From: COOMBER Jason
Sent: 09 April 2019 09:00
To: Anita Gardner
Cc: Daun Johnson
Subject: RE: FG/181/18/PL Ferring Country Centre and Riding Stables

I acknowledge receipt of your e-mail and attachments which I have forwarded to Mrs Johnson. She can't see any difference from the previously submitted plans. Can you confirm what changes you have made? I can't see the access to the site included within the red edge and the building is not clearly identified, there is more than one building outlined in dashes. Could you put an arrow to it. It

Ferring Country Centre And Riding Stables, Rife Way, Ferring, West Sussex, BN12 5JZ

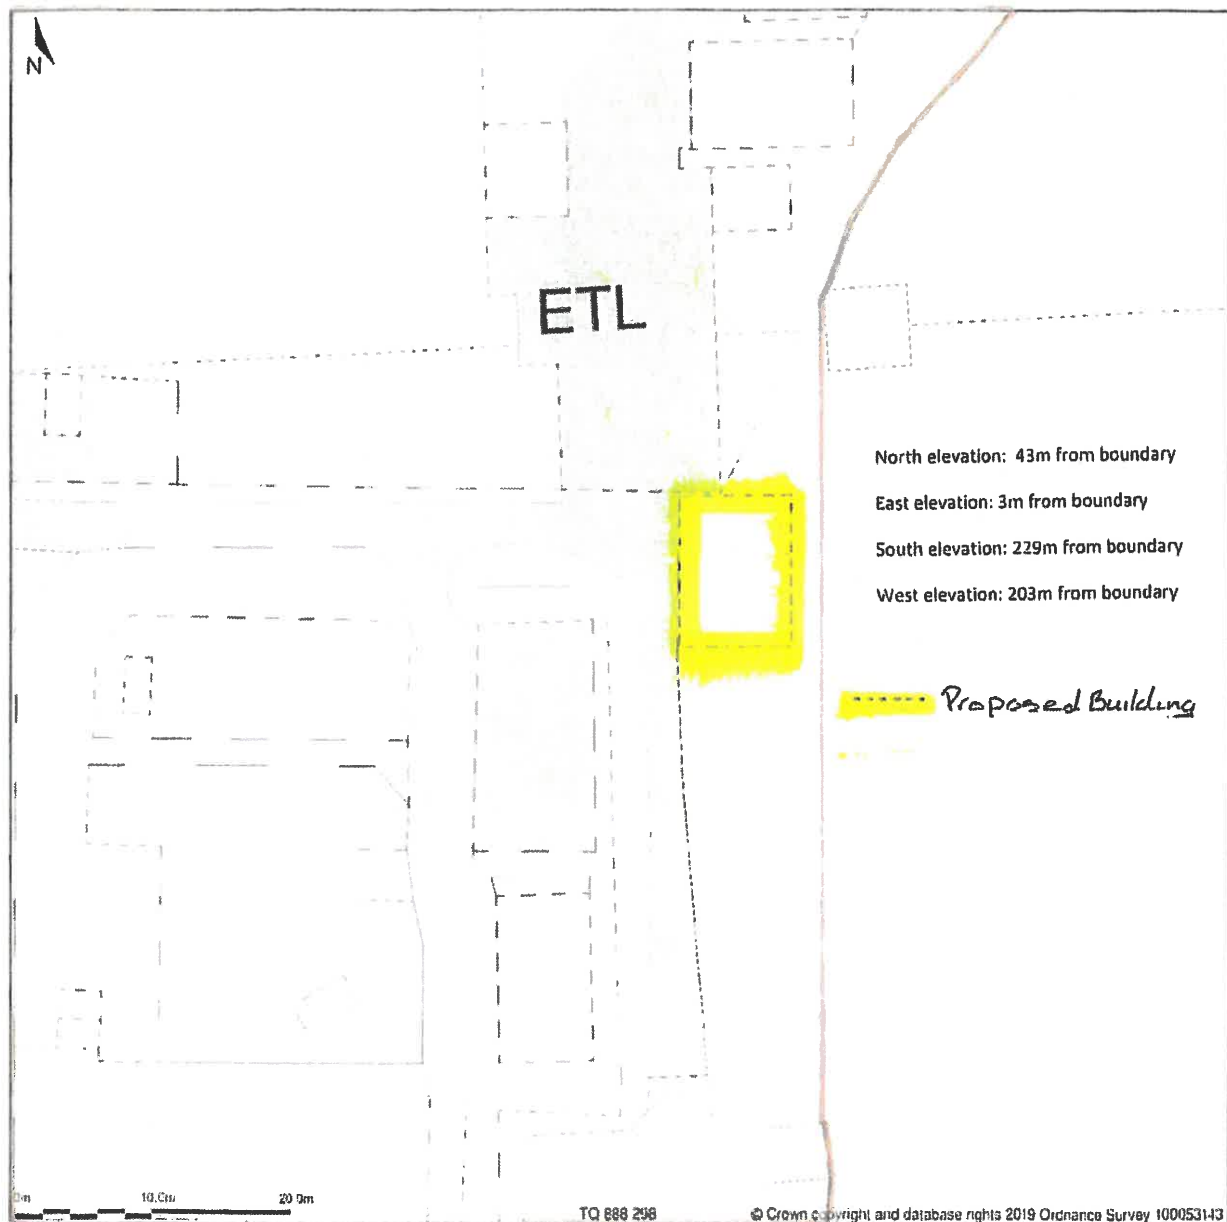
may be helpful to look at the Location Plan on FG/31/17/PL so that you can see the extent of the red edge we are looking for.

I have now attached new plans showing the proposed building in a dashed line with yellow hi-light.

The access to the site is shown with a thin black line and the building is again hi-lighted in yellow and a dashed line.
